Our ref: DOC20/884182

**Subject: Glenellen Solar Farm (SSD 9950) - Review of Environmental Impact Statement**

ATTACHMENT A – BCD Assessment Summary for Glenellen Solar Farm Environmental Impact Statement (SSD 9550)

Figure 1-11 0.5% AEP (200-year ARI) maximum flood extent with depths in metres for existing conditions. Red polygon represents the Site

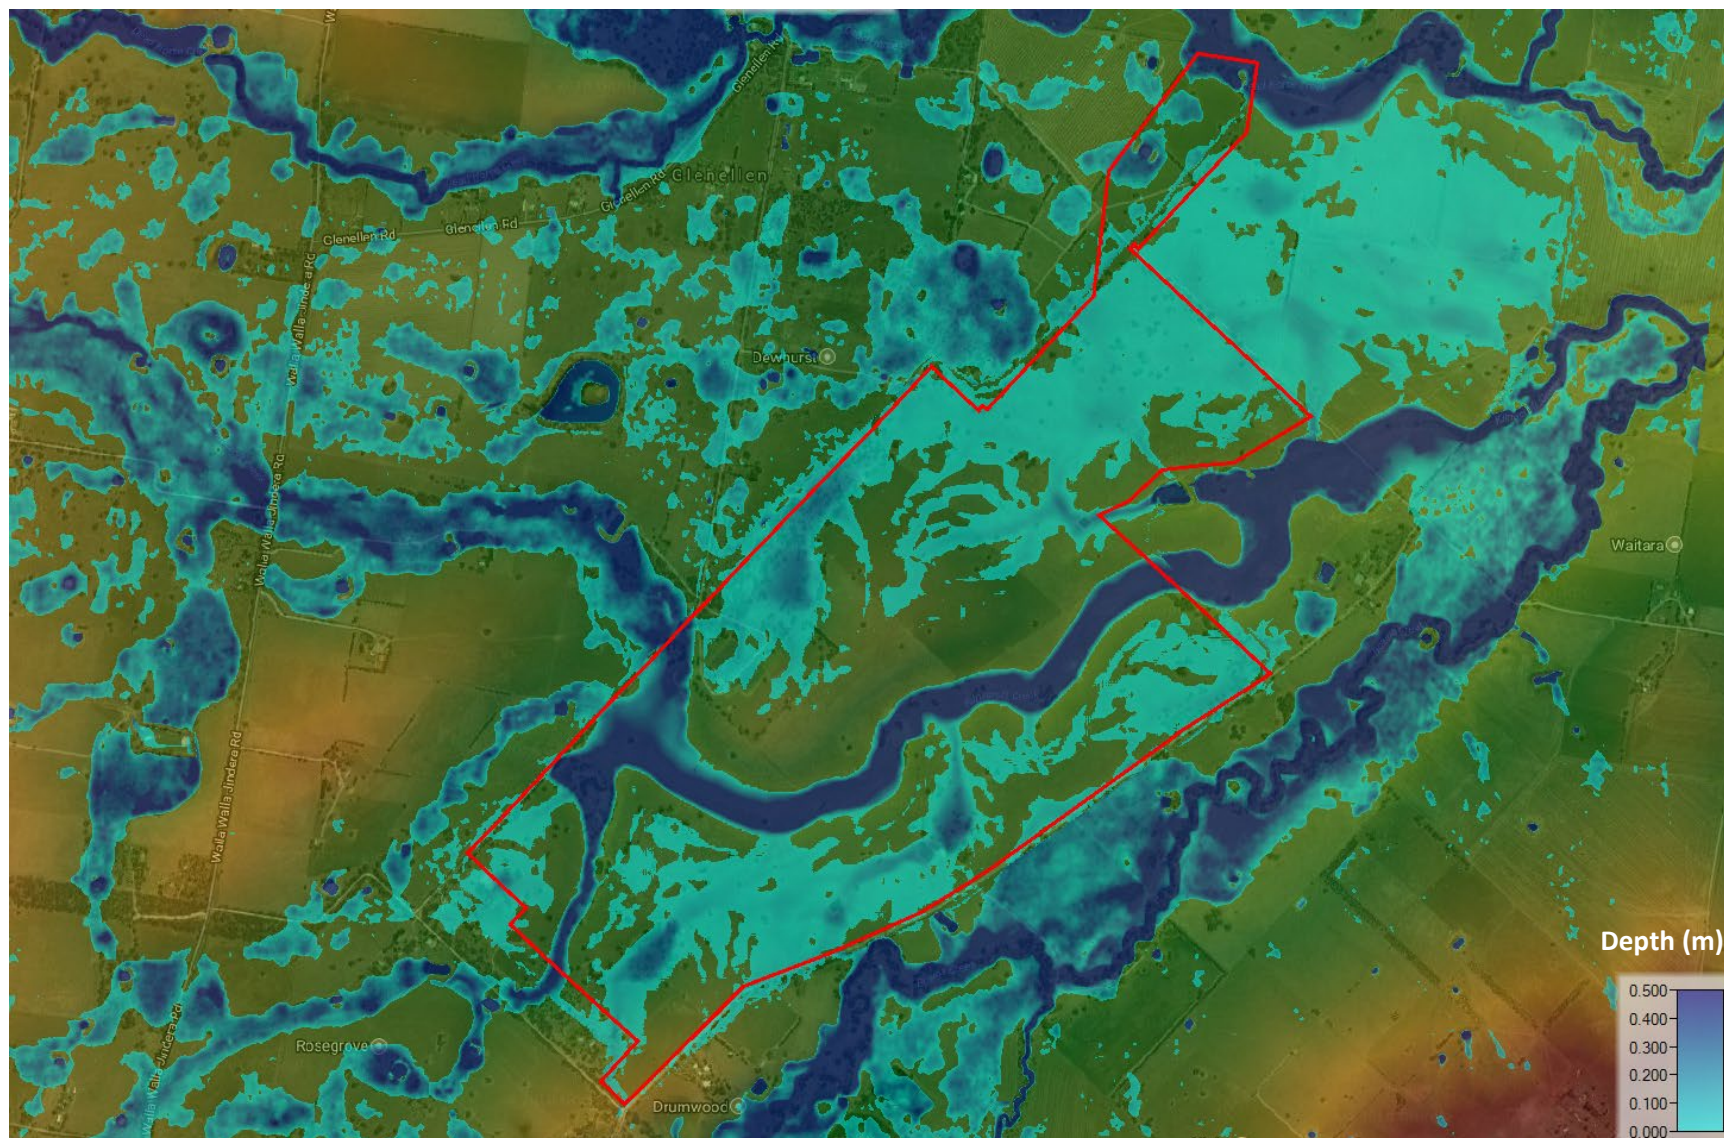
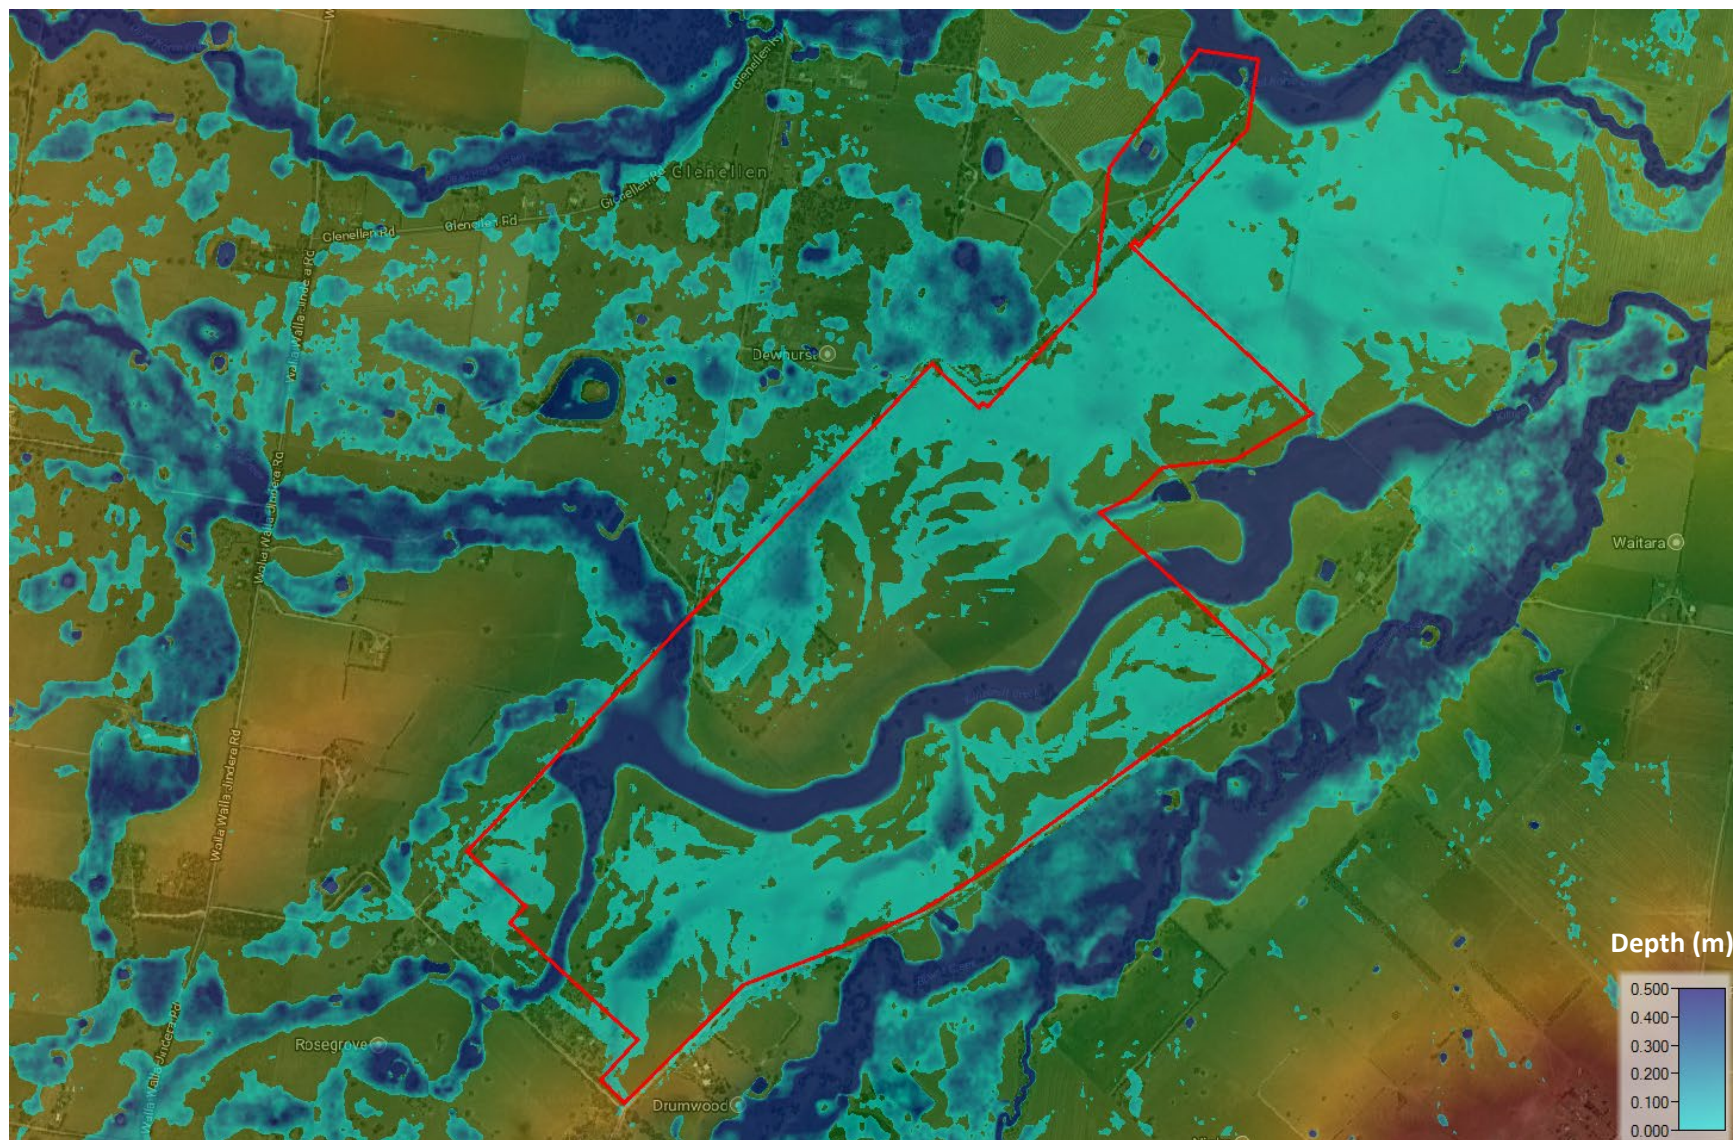
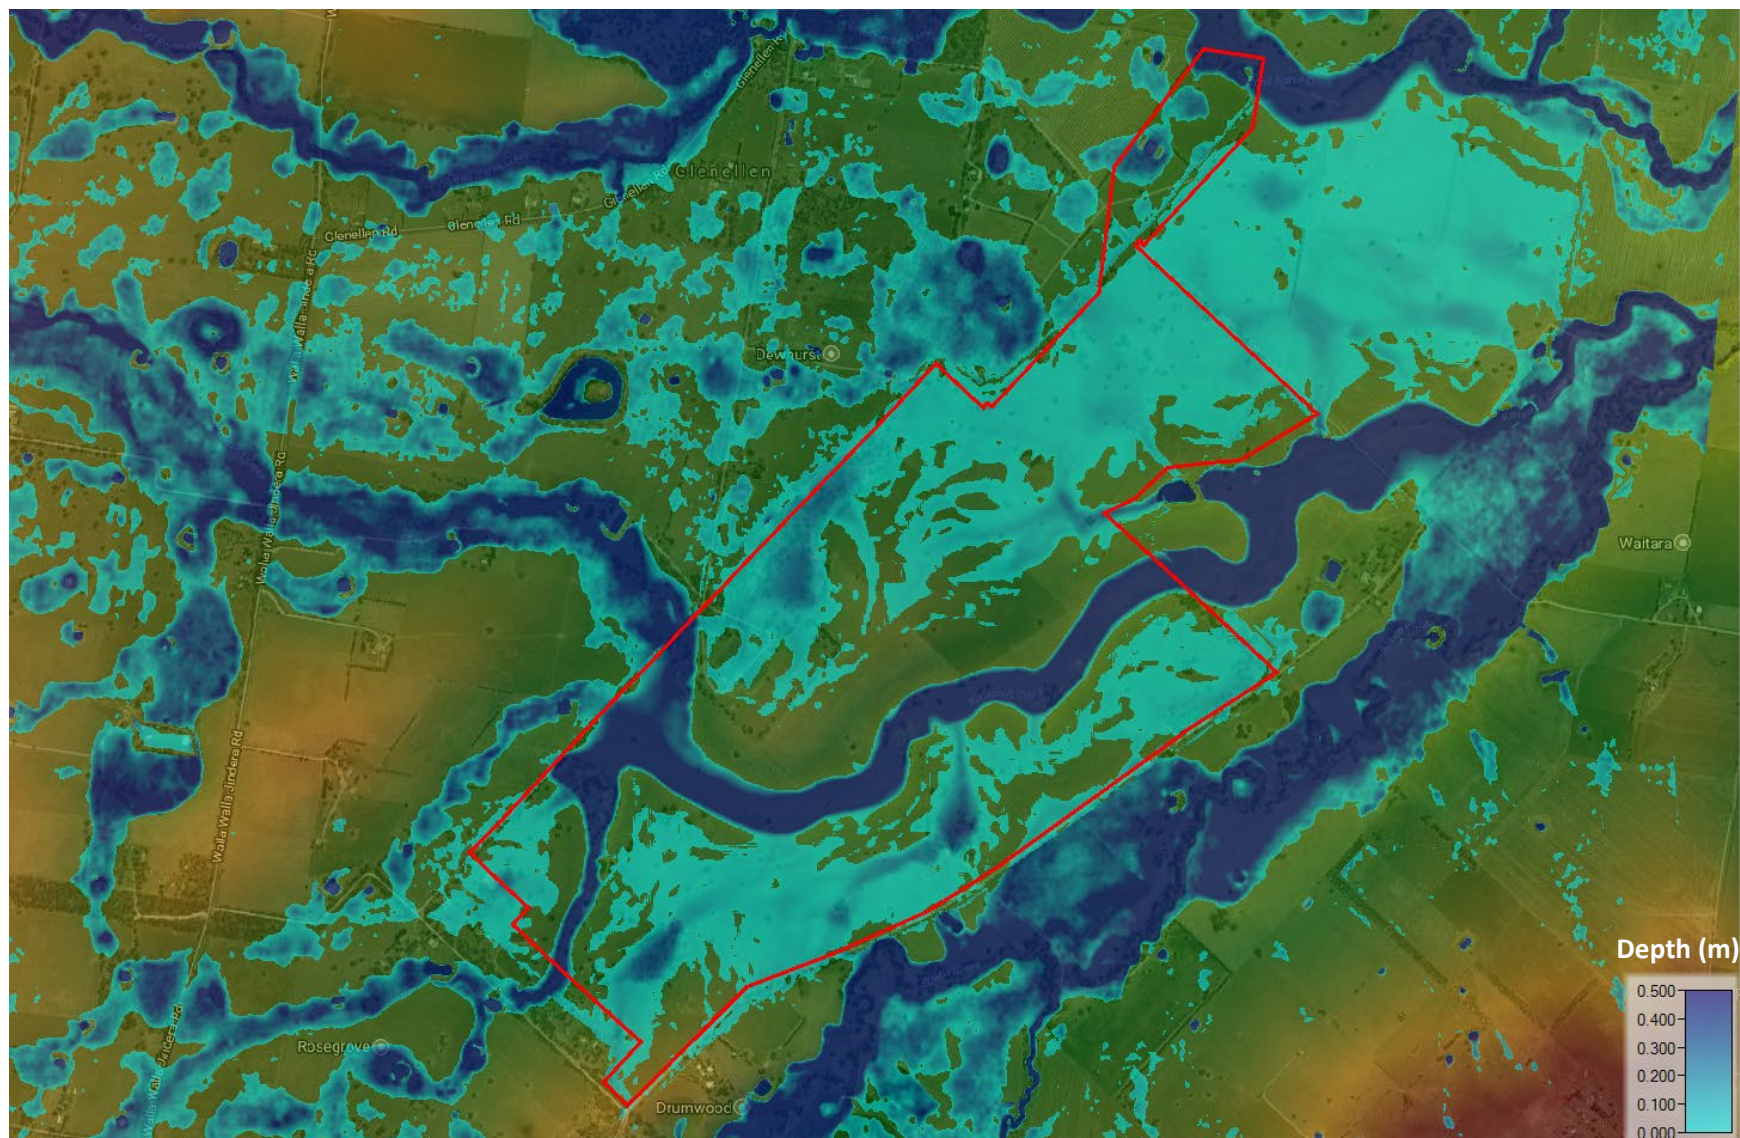
Existing conditions inundation extent maps were generated for 10% Annual Exceedance Probability (AEP), 1% AEP, 0.5 AEP%, 0.2% AEP and 0.1% AEP (1 in ~10-year, 100-year, 200-year, 500-year and 1000-year Annual Recurrence Interval (ARI), respectively).

The flood mapping shows significant flow paths crossing the site that develop during local intense rainfall events in all design events.

No flood mapping has been developed that show the flood hazards or hydraulic categories (floodways, flood storage and flood fringe areas) across the site. This is needed for the appropriate locating of infrastructure.

1. The proponent must be required to complete additional flood modelling in the detailed design phase to define the flood hazards and hydraulic categories across the development site prior to finalising the location of critical infrastructure.

Figure 1-14 Locations of proposed building pads and the modelled water depths in metres for the 1% AEP (100 year ARI) event. The cross section used for downstream impact assessment is also shown ('XS Location'). Red polygon represents the Site

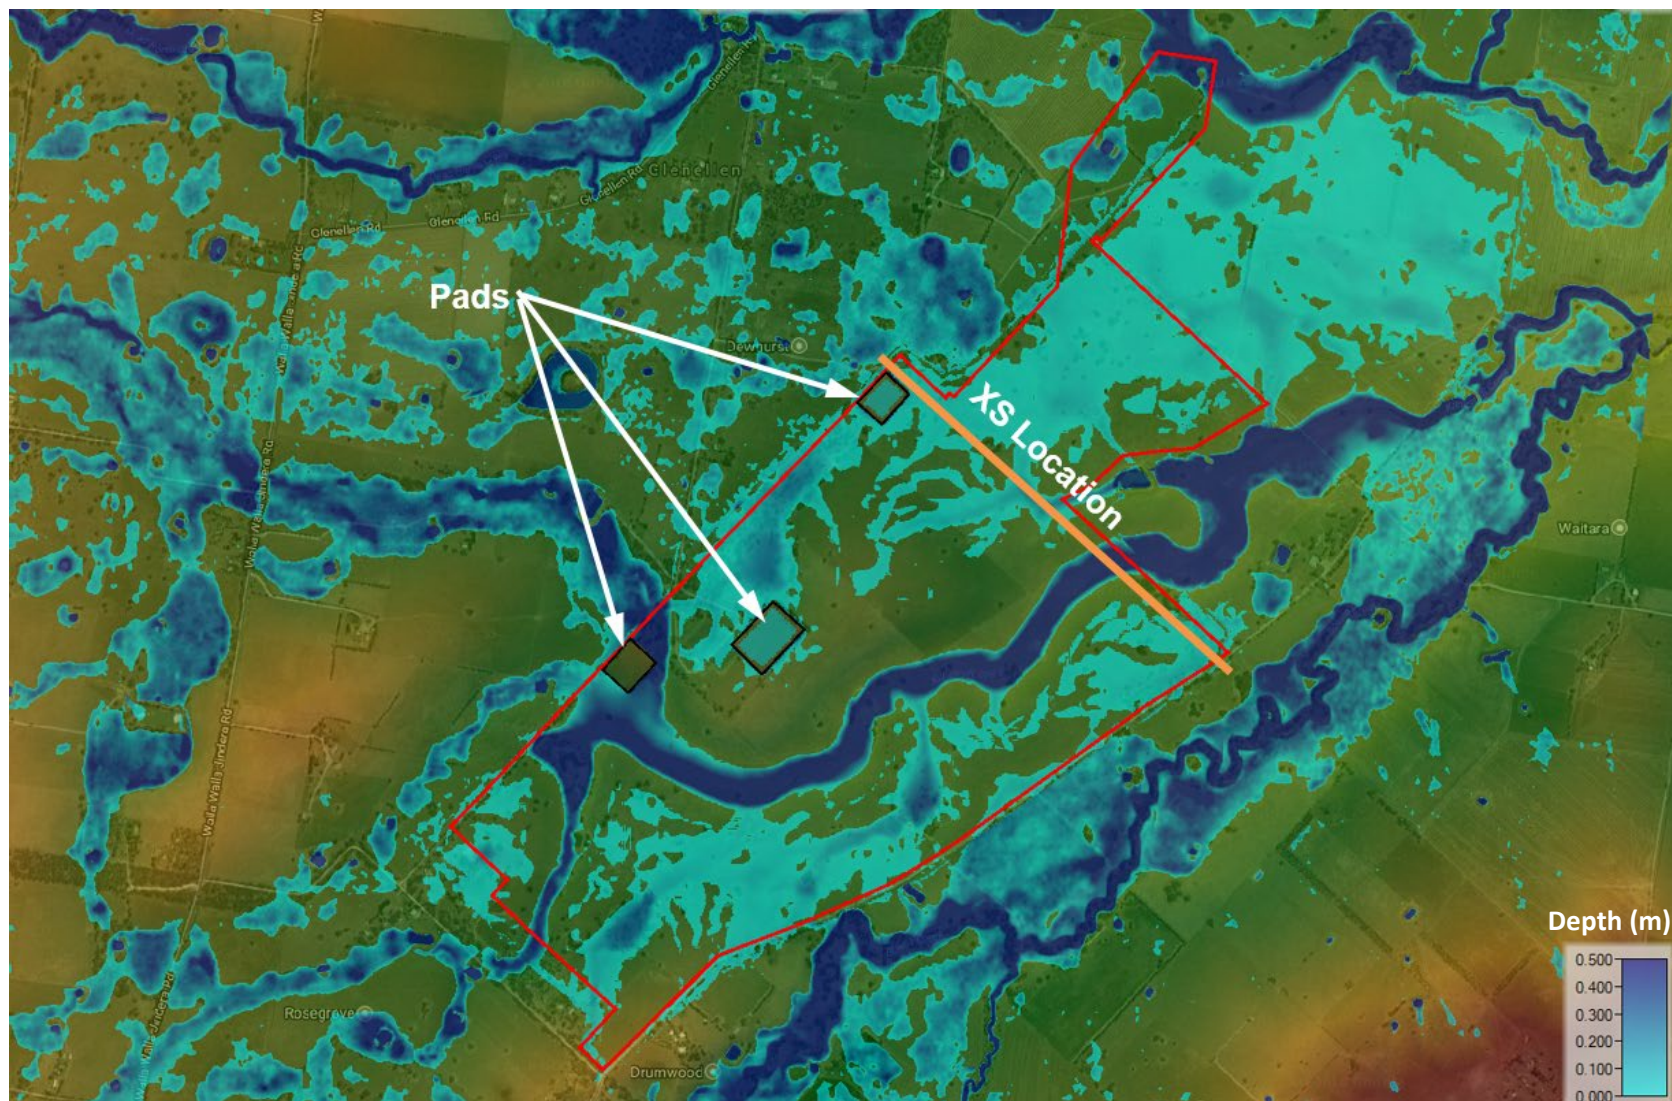
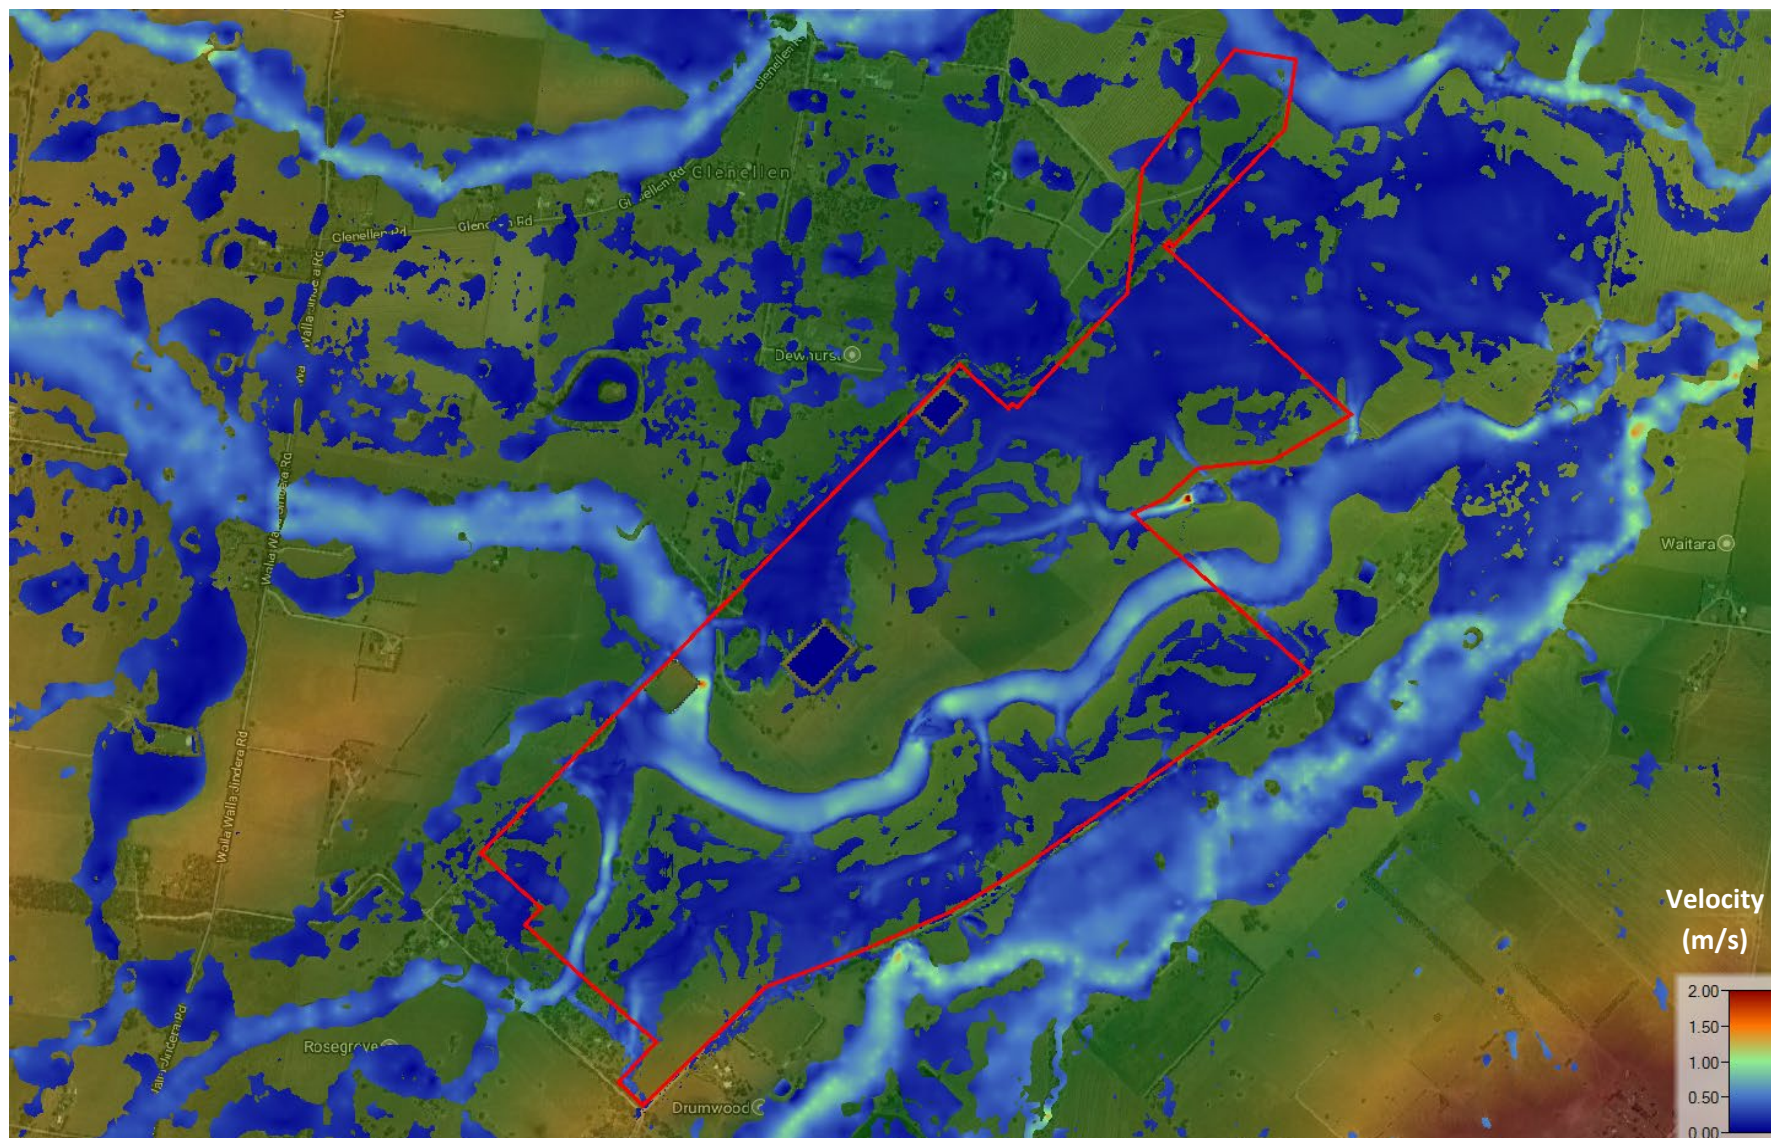
To determine the impact of the proposed development on flooding, indicative temporary construction pads, substation and battery storage areas were added to the rain-on-grid model as raised terrain to assess potential changes in flood hydrology. These have been placed in arbitrarily chosen locations for modelling purposes and may not be constructed in those locations (subject to detailed design). The effect of the installation of the solar arrays and security fencing around the site was not modelled as they were considered likely to only be of a minor impact.

For larger events (1 in 100-year ARI, or 1% AEP), in the immediate vicinity of the pads, it was found that water surface elevations are likely to increase by up to 200 mm. Also in some areas around the temporary construction pads, the flow path is likely to be constricted, and the increased flow velocities may require the use of armour rock to prevent local scour.
